# MIDTOWN COLLECTION AT HANNAH RIDGE

### PUD DEVELOPMENT PLAN AND PRELIMINARY PLAN

**MIDTOWN COLLECTION AT HANNAH RIDGE PUD DEVELOPMENT PLAN & PRELIM. PLAN**  
 FILING NO. 1 AND FILING NO. 2  
 COVER SHEET

TYPICAL LOT DETAILS

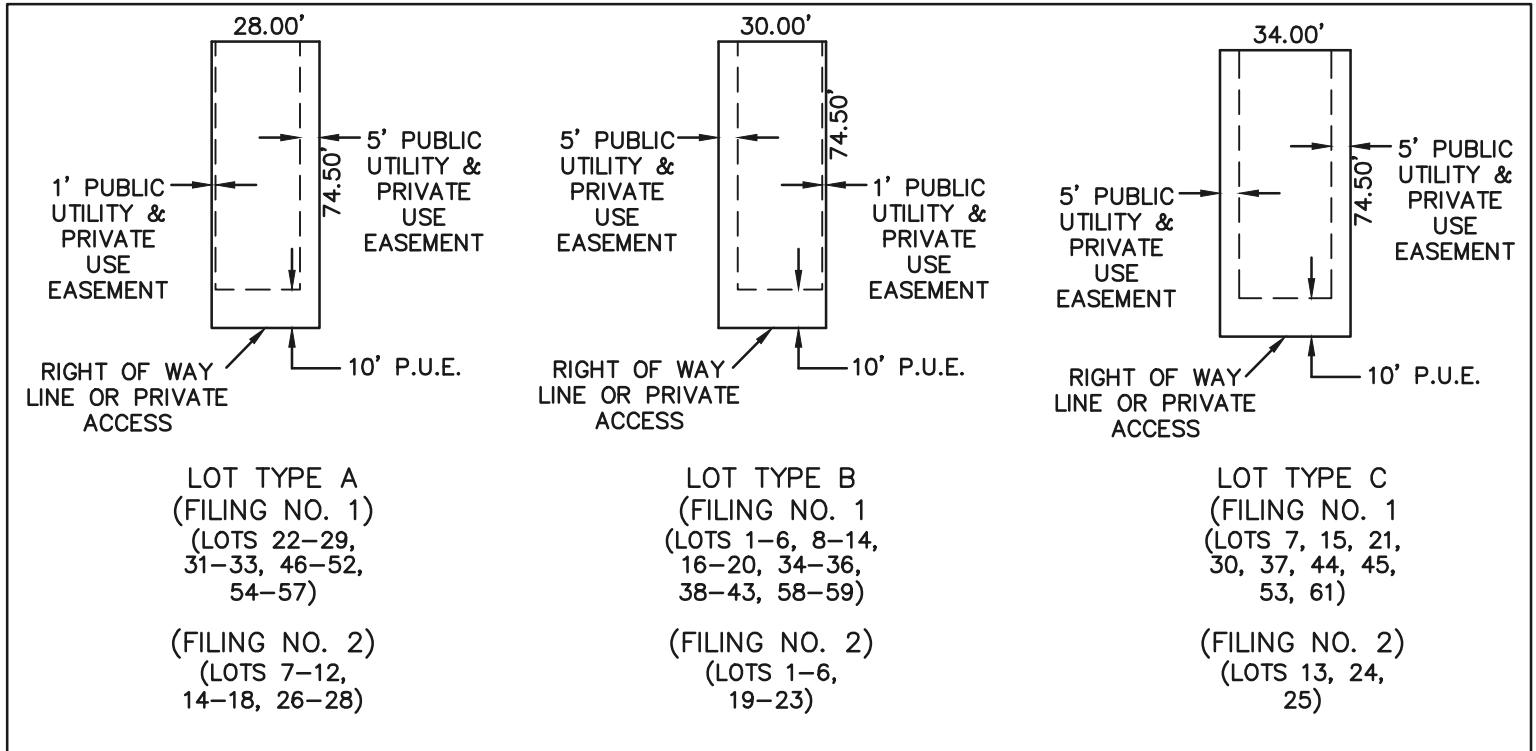
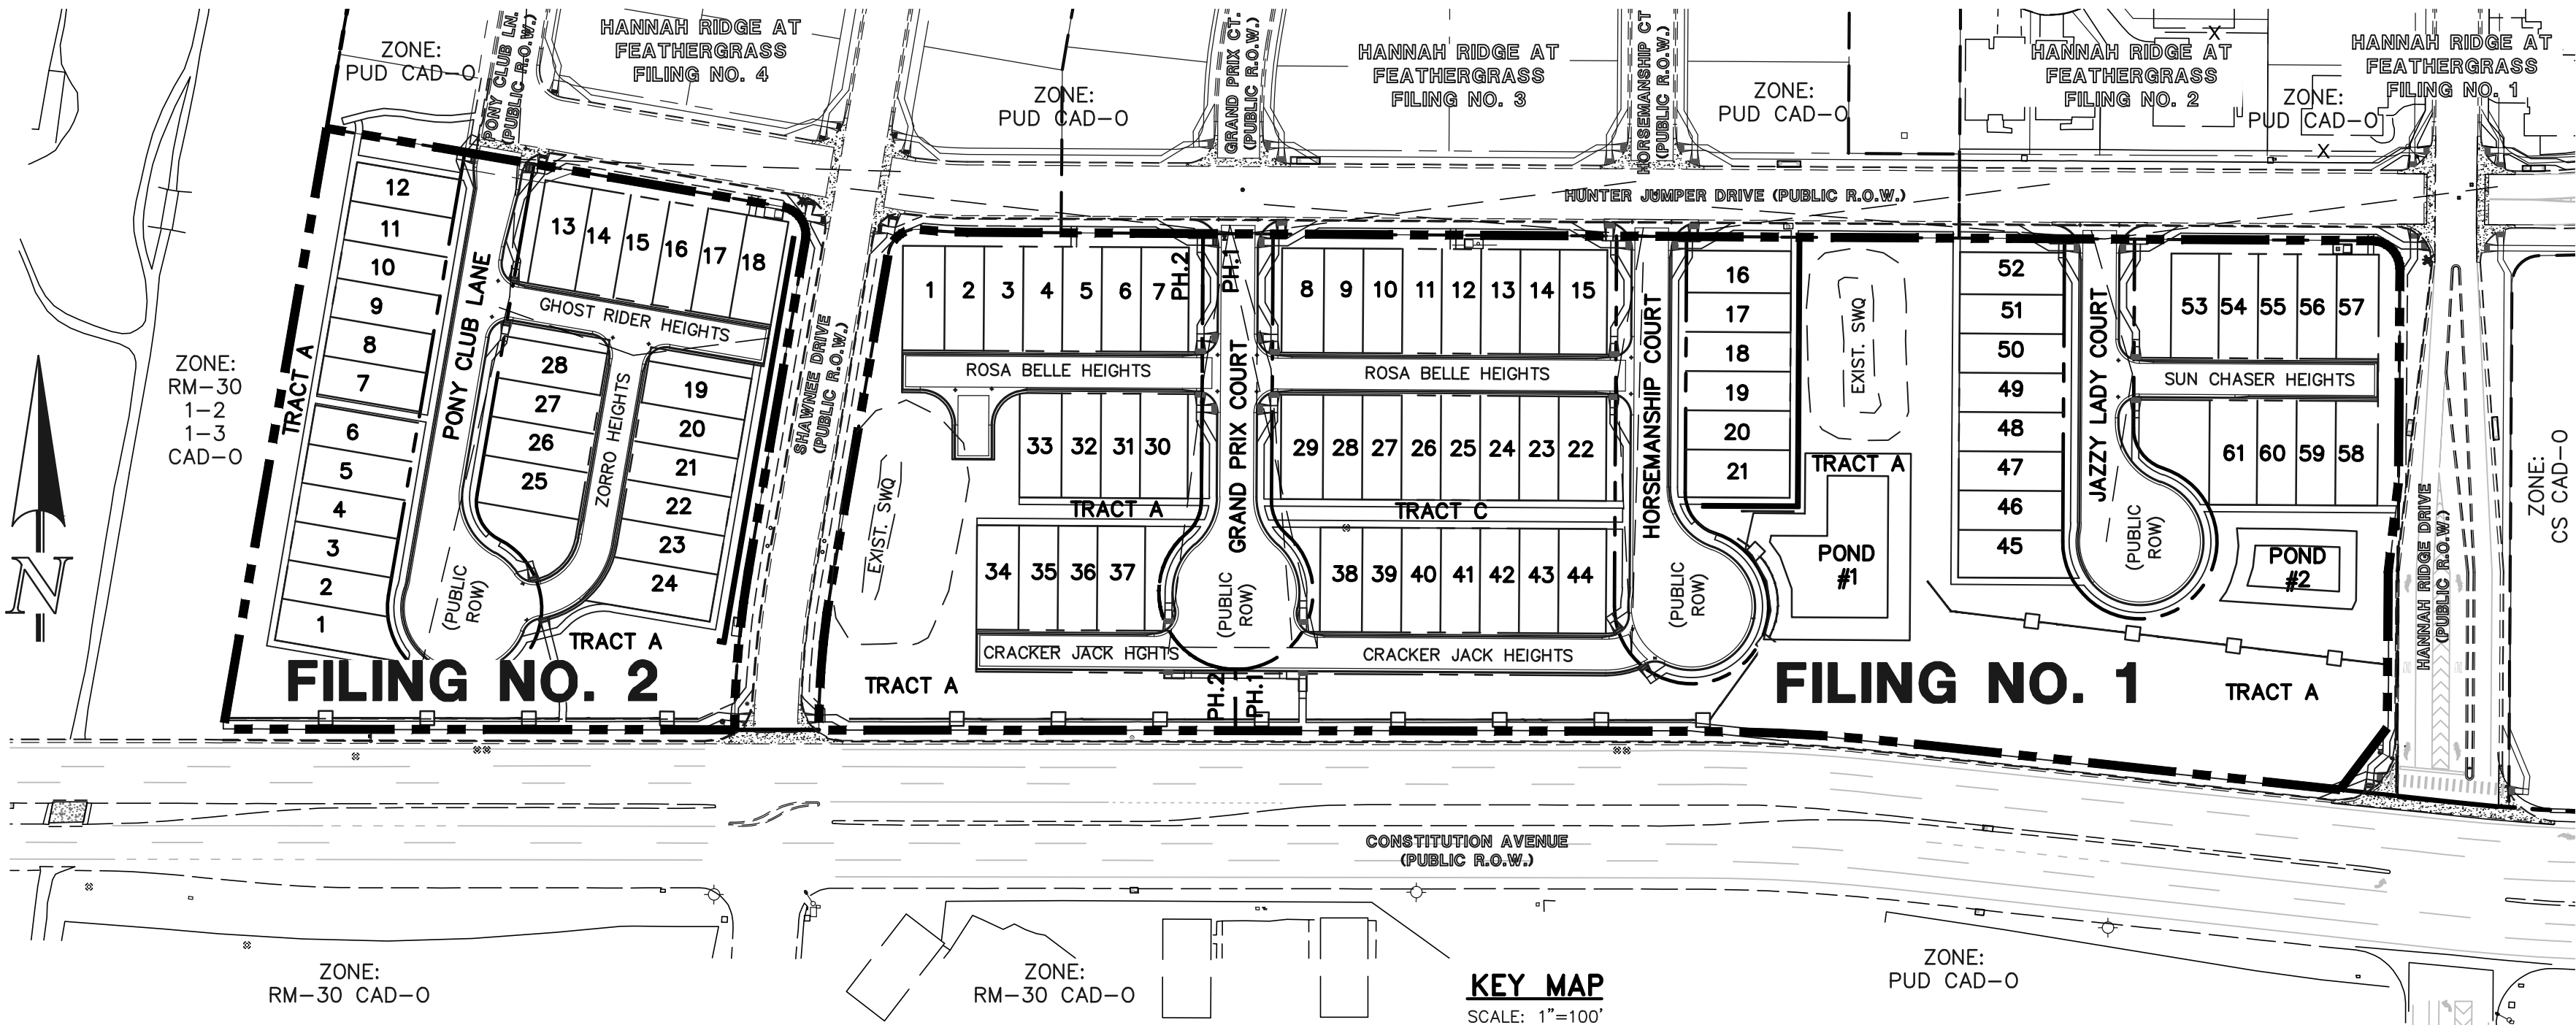
is the garage in the 20' setback? it looks like it is... Your parking on the driveway so the vehicle should not hang over the sidewalk- check all typicals please

MIDTOWN COLLECTION AT HANNAH RIDGE
PUD DEVELOPMENT PLAN & PRELIM. PLAN

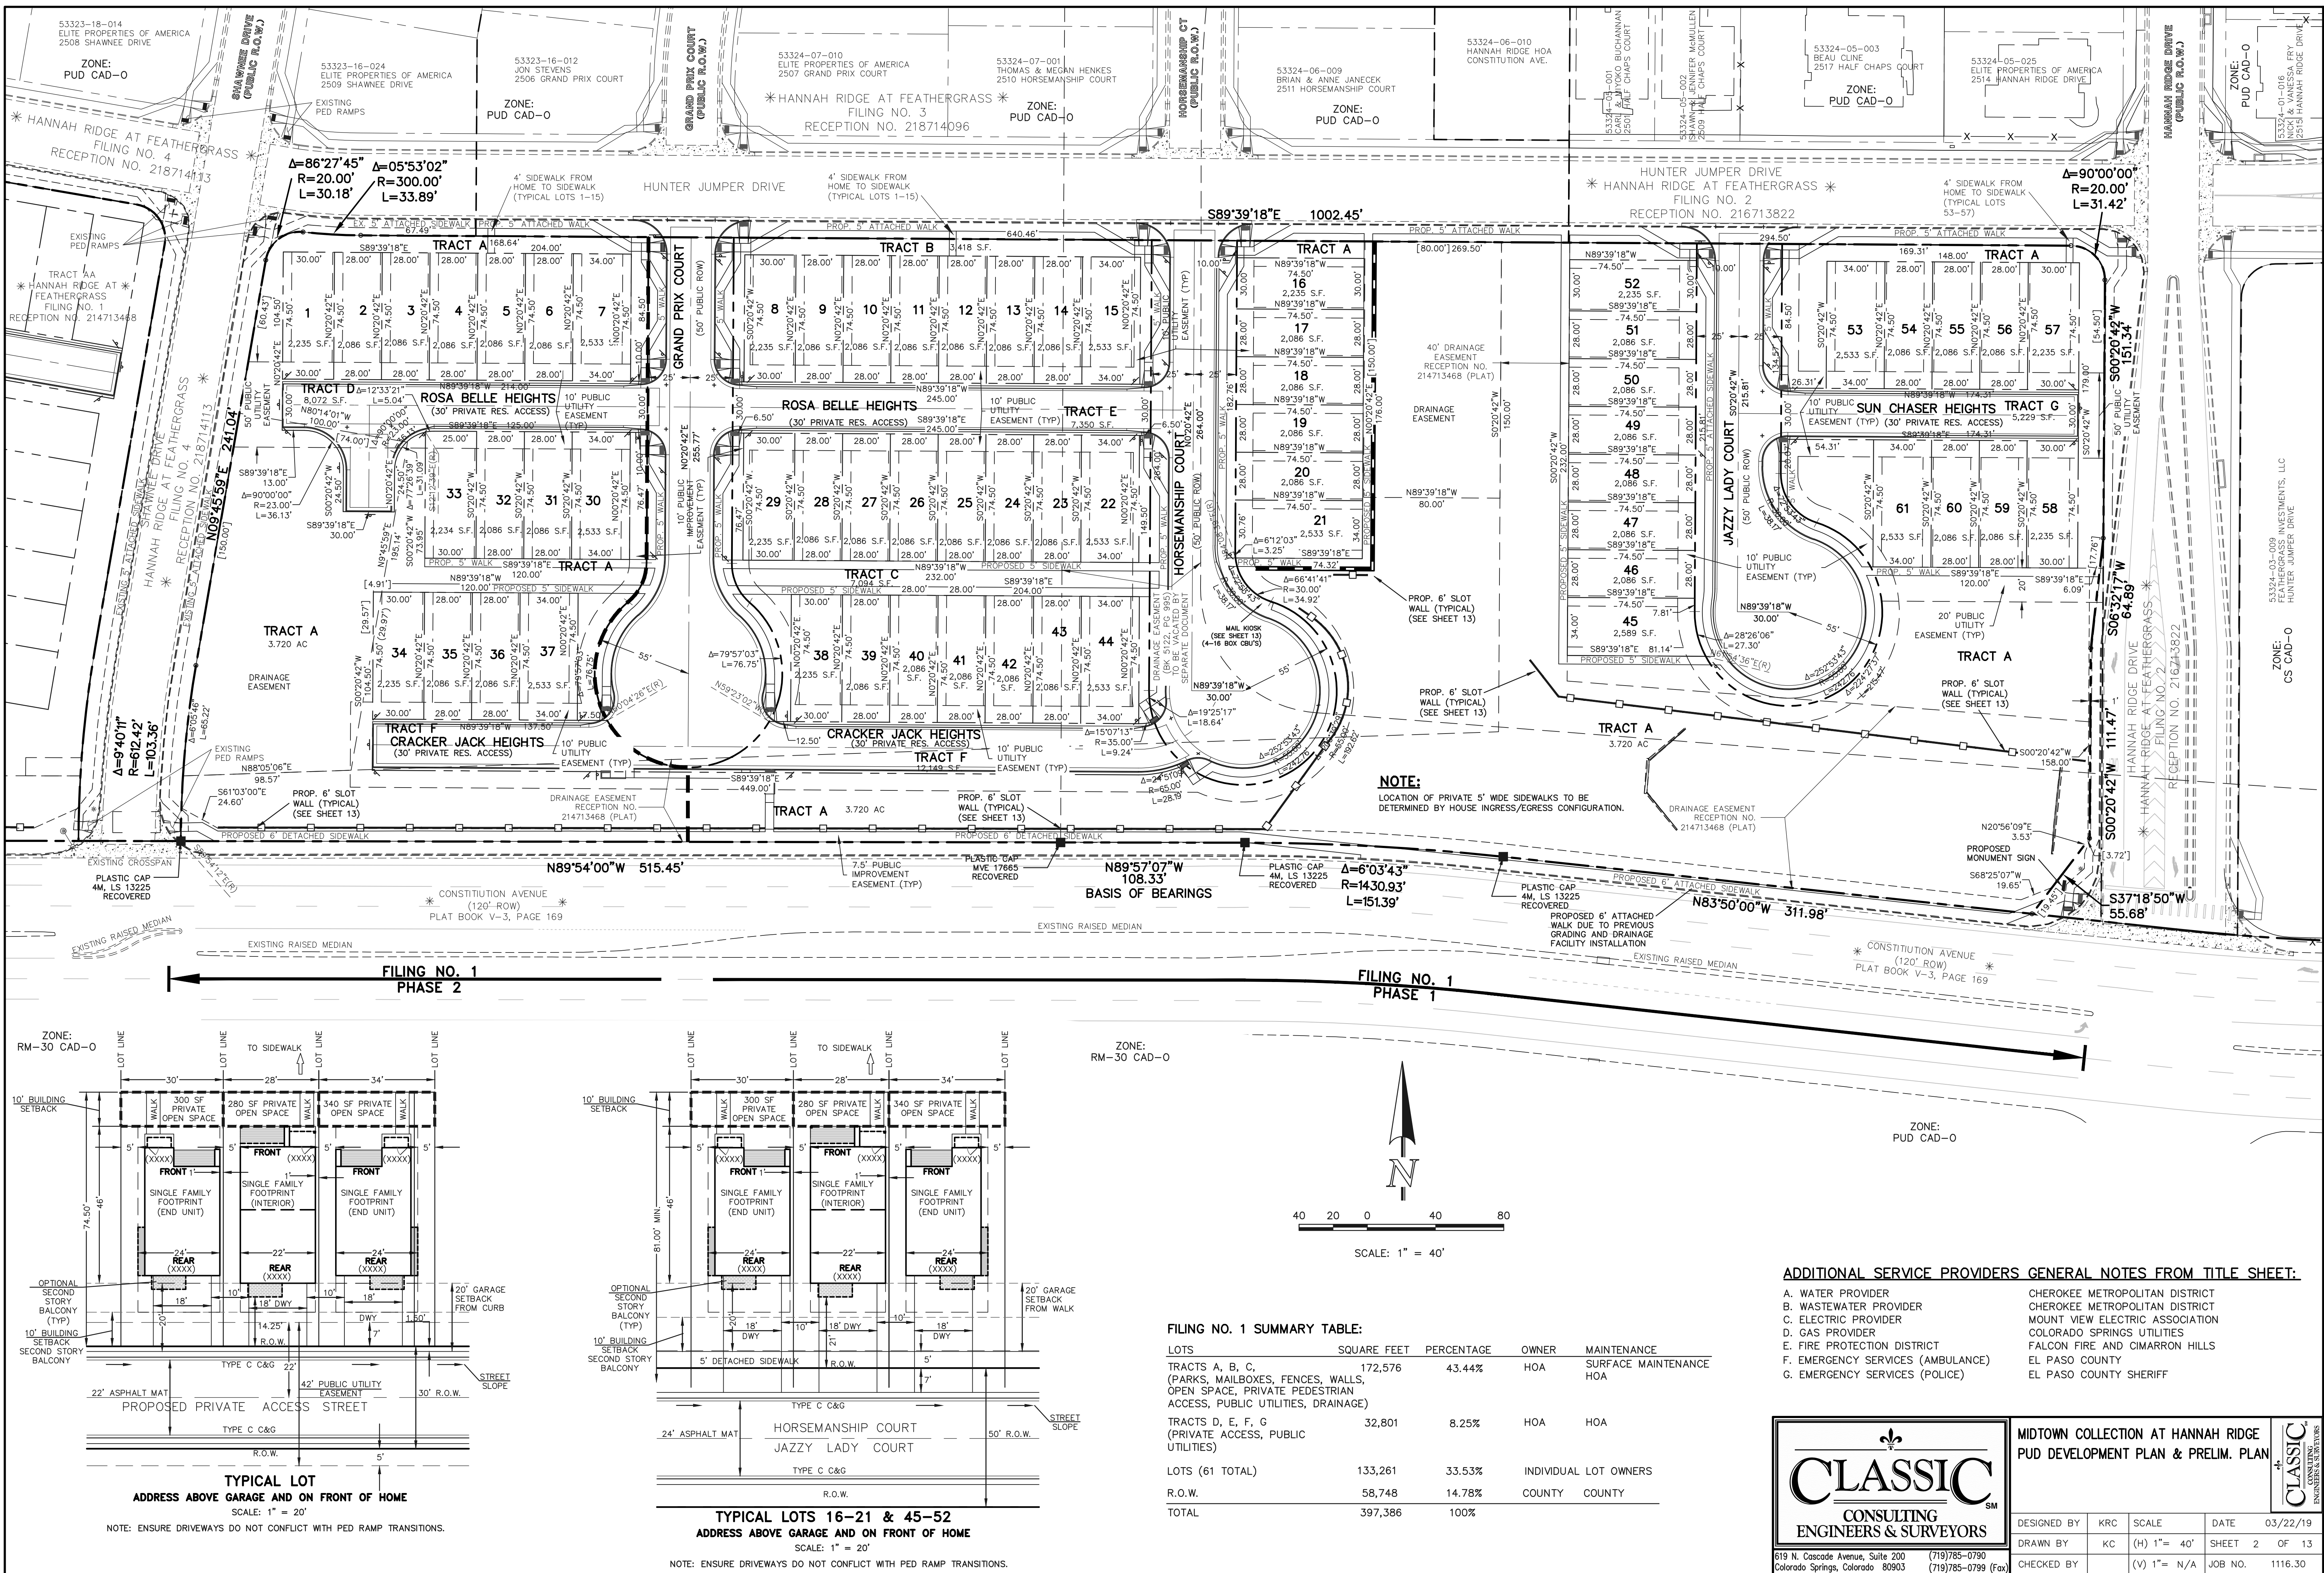
what is surface maintenance of these tracts mean?
